VPI Immingham OCGT Project

Document Ref: 7.2
PINS Ref: EN010097

Applicant's Response to Examining Authority's First Written Questions

Applicant: VPI Immingham B Ltd
Date: September 2019

Drawing Title
OTHER DEVELOPMENTS CONSIDERED FOR CUMULATIVE IMPACTS FIGURE 17.1

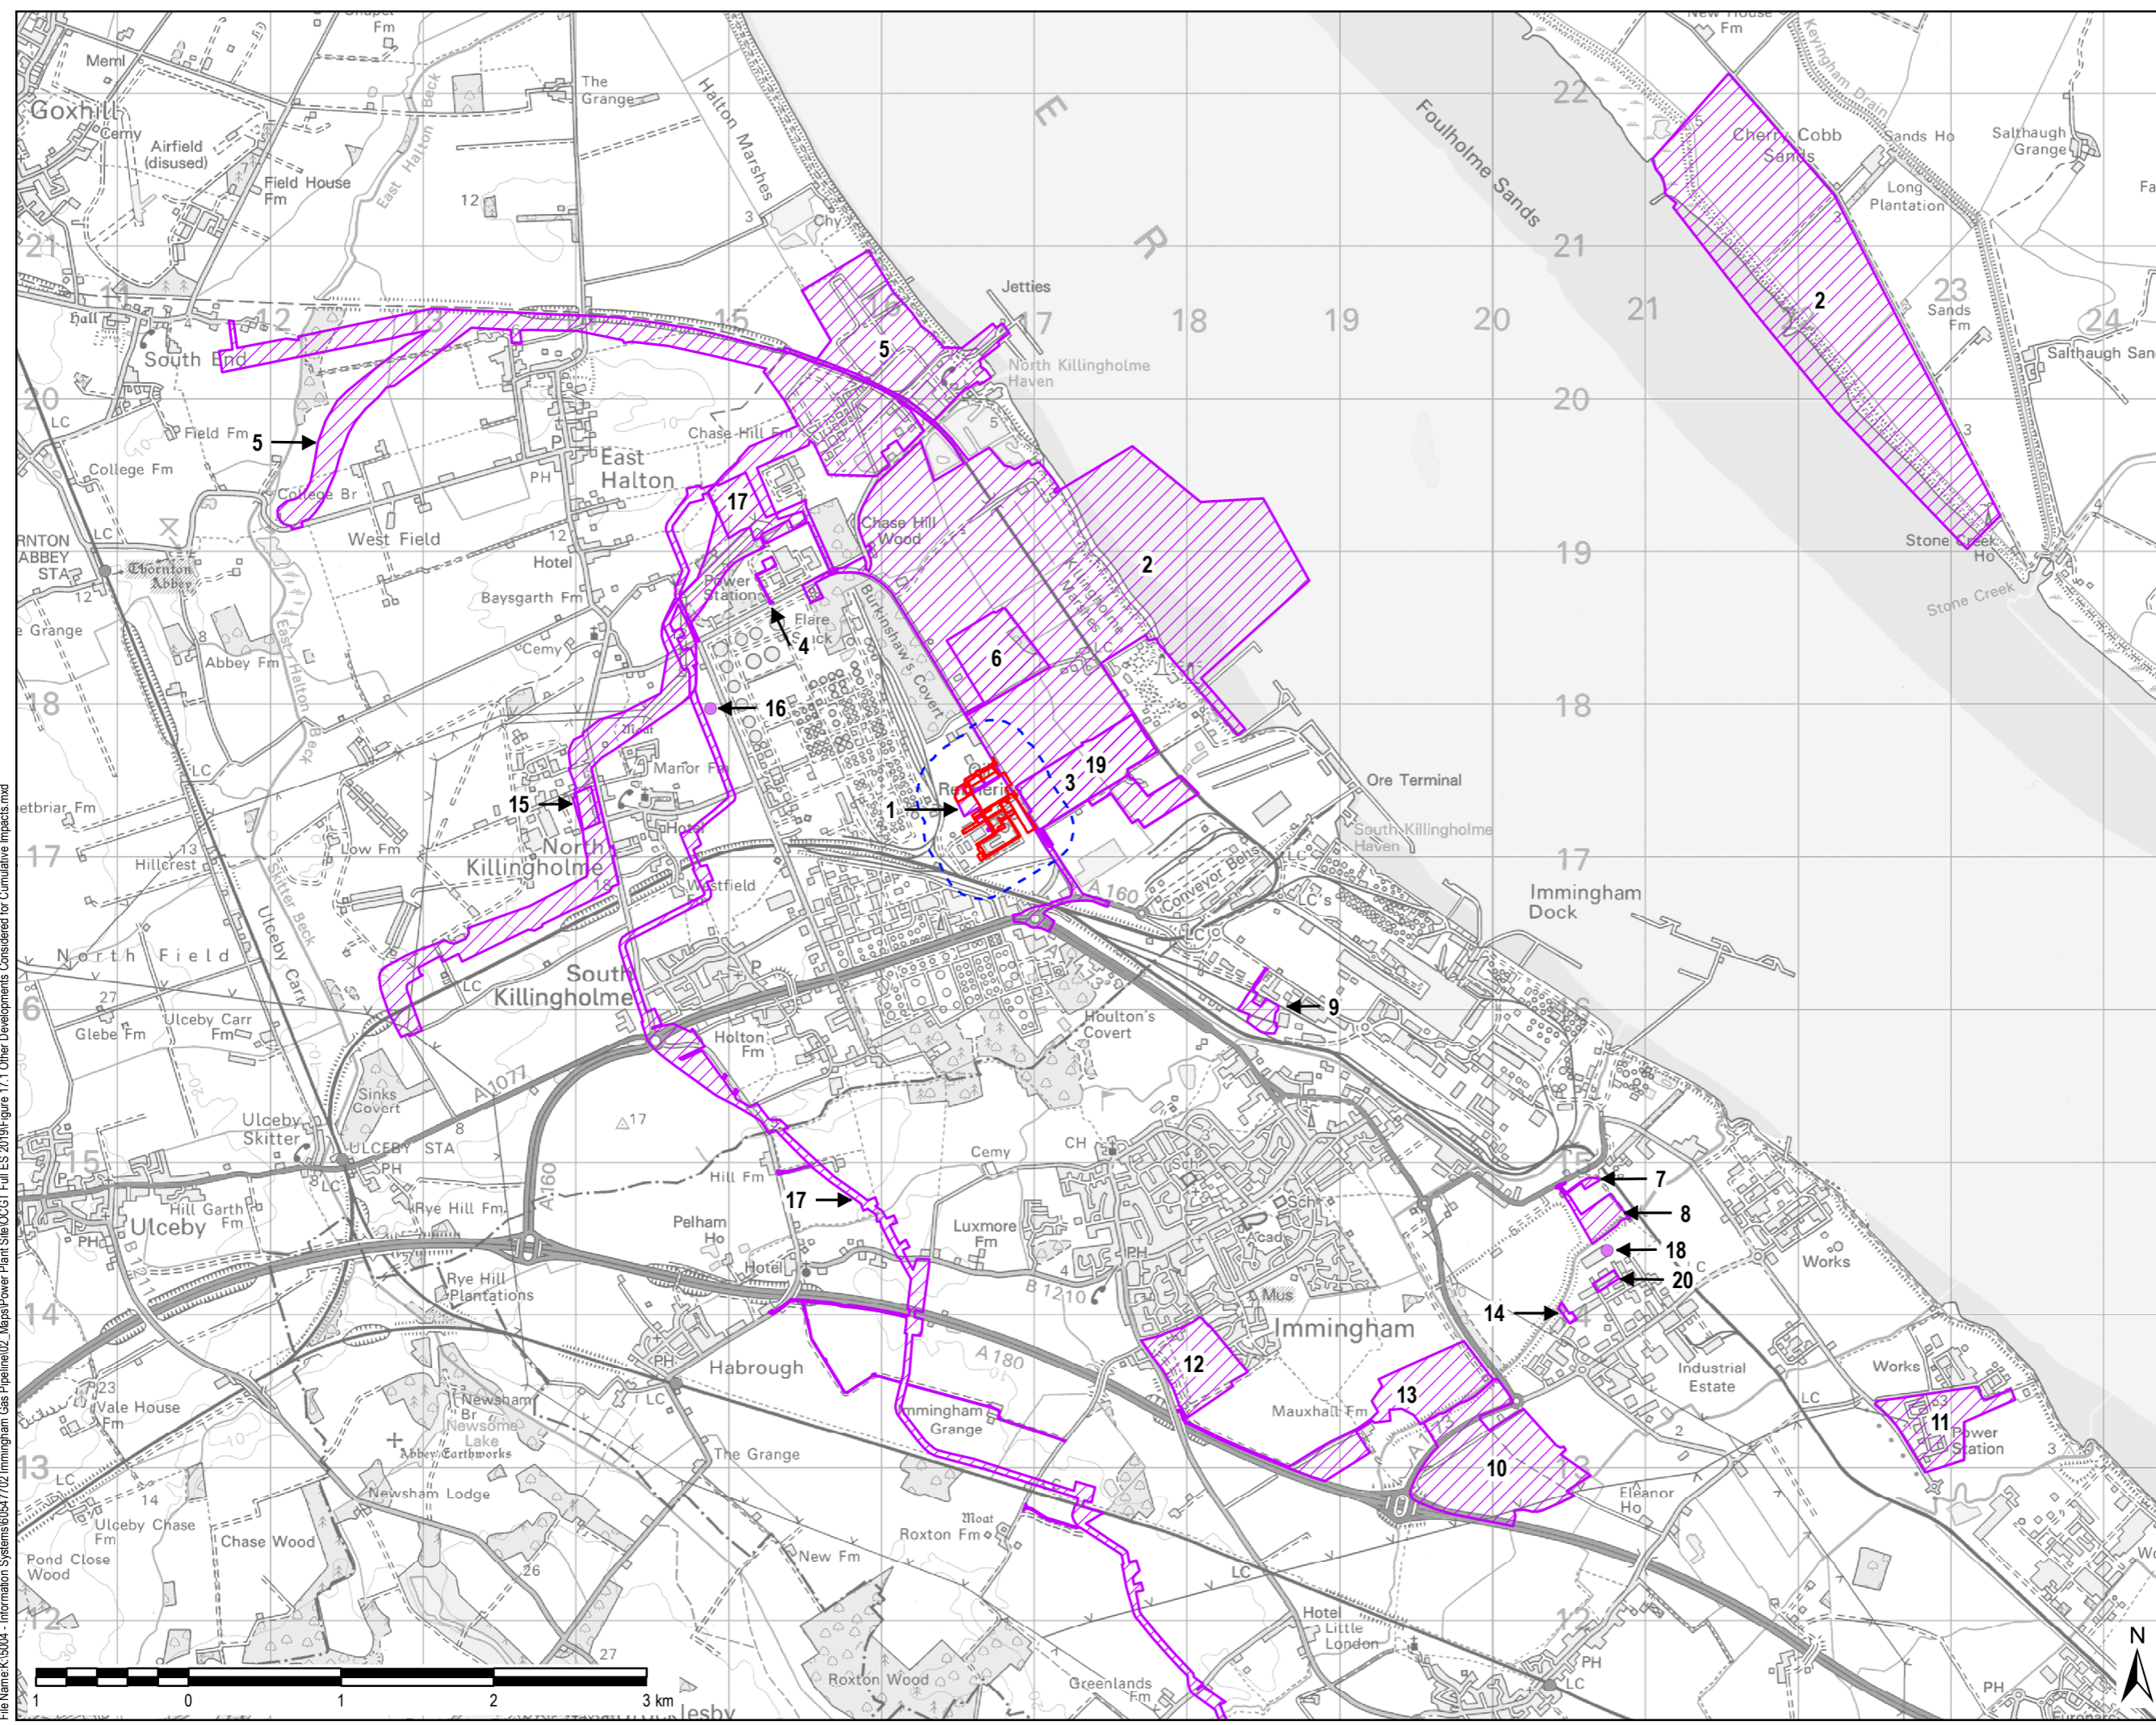
Q1.1.9	Traffic Construction Assessment 2021 baseline	The construction traffic assessment 2021 baseline includes forecast models that include committed developments. The committed developments are stated in [APP- 046] ES Chapter 17 Cumulative and Combined Effects and [APP-073] Figure 17.1. It is	The baseline flows used as the basis for traffic assessment uses automatic traffic counts from 2016 and 2018 and was the most up to date information available at the time of writing. As discussed in the response to question 1.1.4, background air quality data mapping from the Defra
